# The Planning Act 2008

## Section 55 Acceptance of Applications

### Section 55 Application Checklist<sup>1</sup>

Document number  
4.9

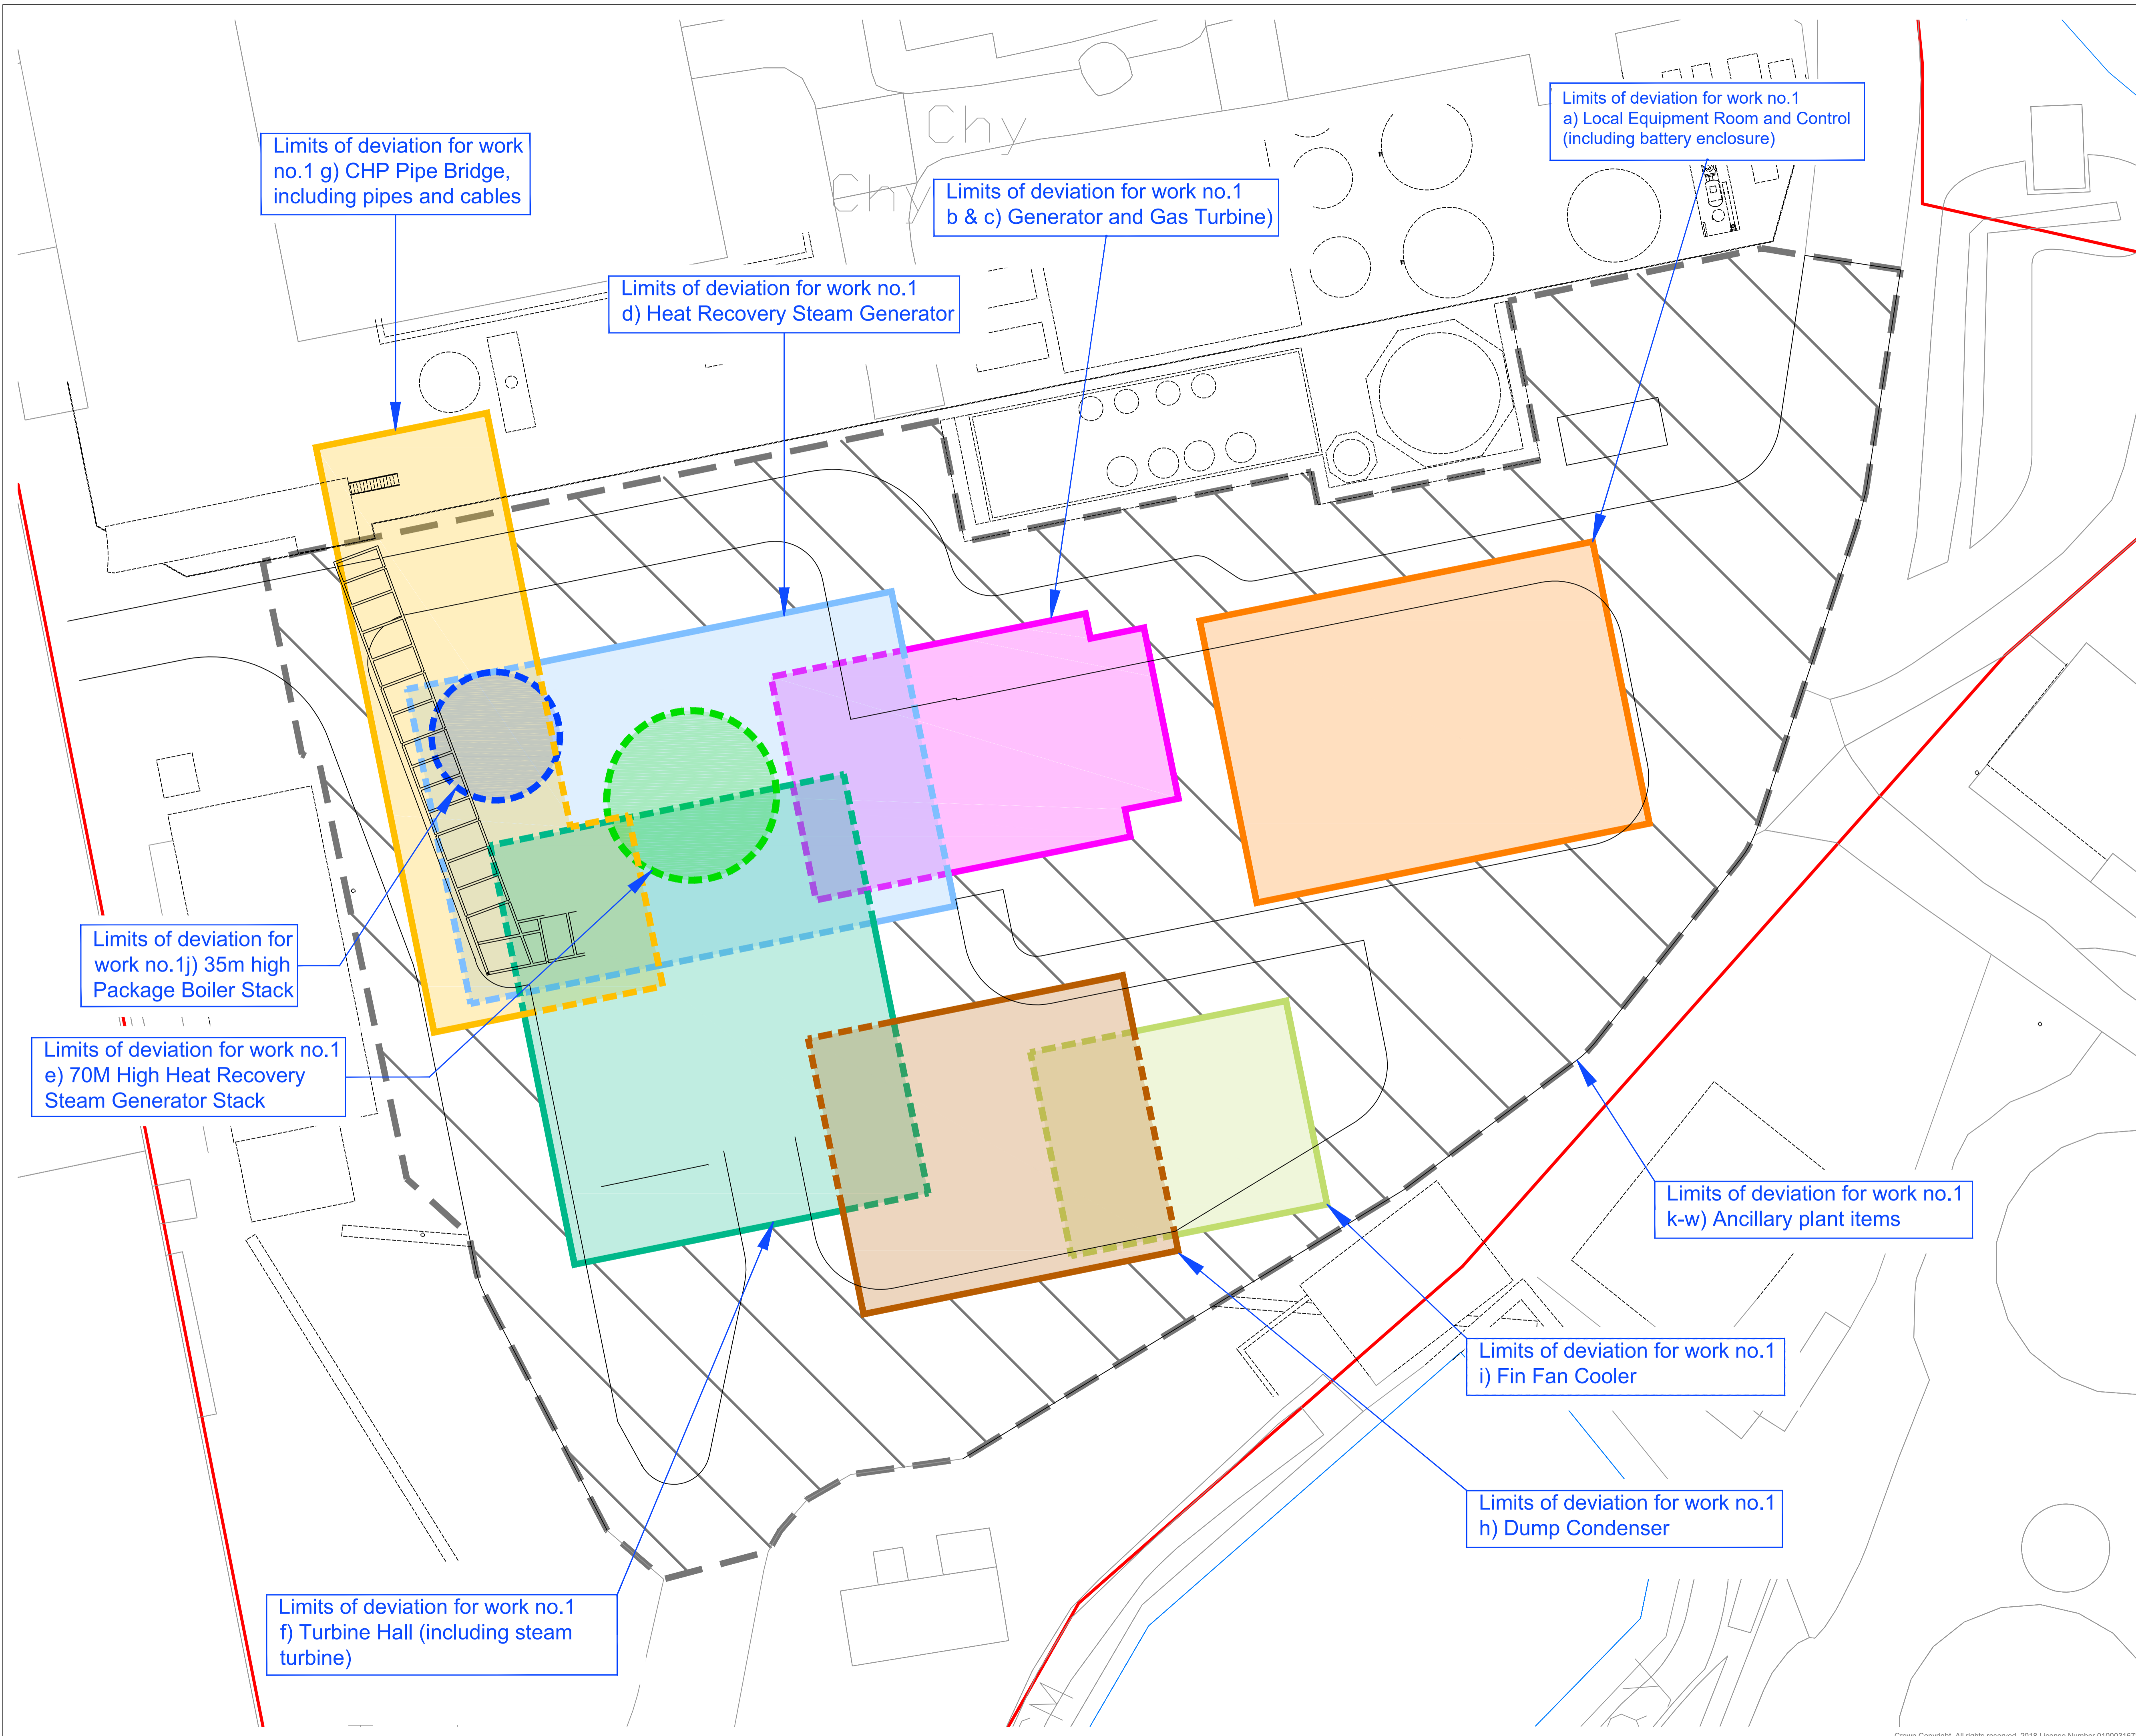
See comments below pertaining to **Reg. 5(2)(o)** of the APFP in regards to Works No.1(g). It should be noted that upon review of **Doc 4.9** in conjunction with plan titled **Illustrative layout with vertical tube boiler (Doc 4.10)** it appears that Work number 1(g) as illustrated in **Doc 4.9** (*CHP Pipe Bridge, including pipes and cables*) is not positioned at a 90° angle as depicted in **Doc 4.10** for the Vertical Tube Boiler. It may therefore be necessary to update these plans accordingly.

It should be noted that Works number 1(g) as illustrated in **Doc 4.9**, specifically the illustrative laydown of the “*CHP Pipe Bridge, including pipes and cables*”, appears to be identical to that depicted in **Doc 4.5**. However, upon review of **Doc 4.10** (see comments above regarding Regulation

5(2)(j)), this particular “Main Plant item” should run at a 90° angle. It may therefore be necessary to update these plans accordingly.
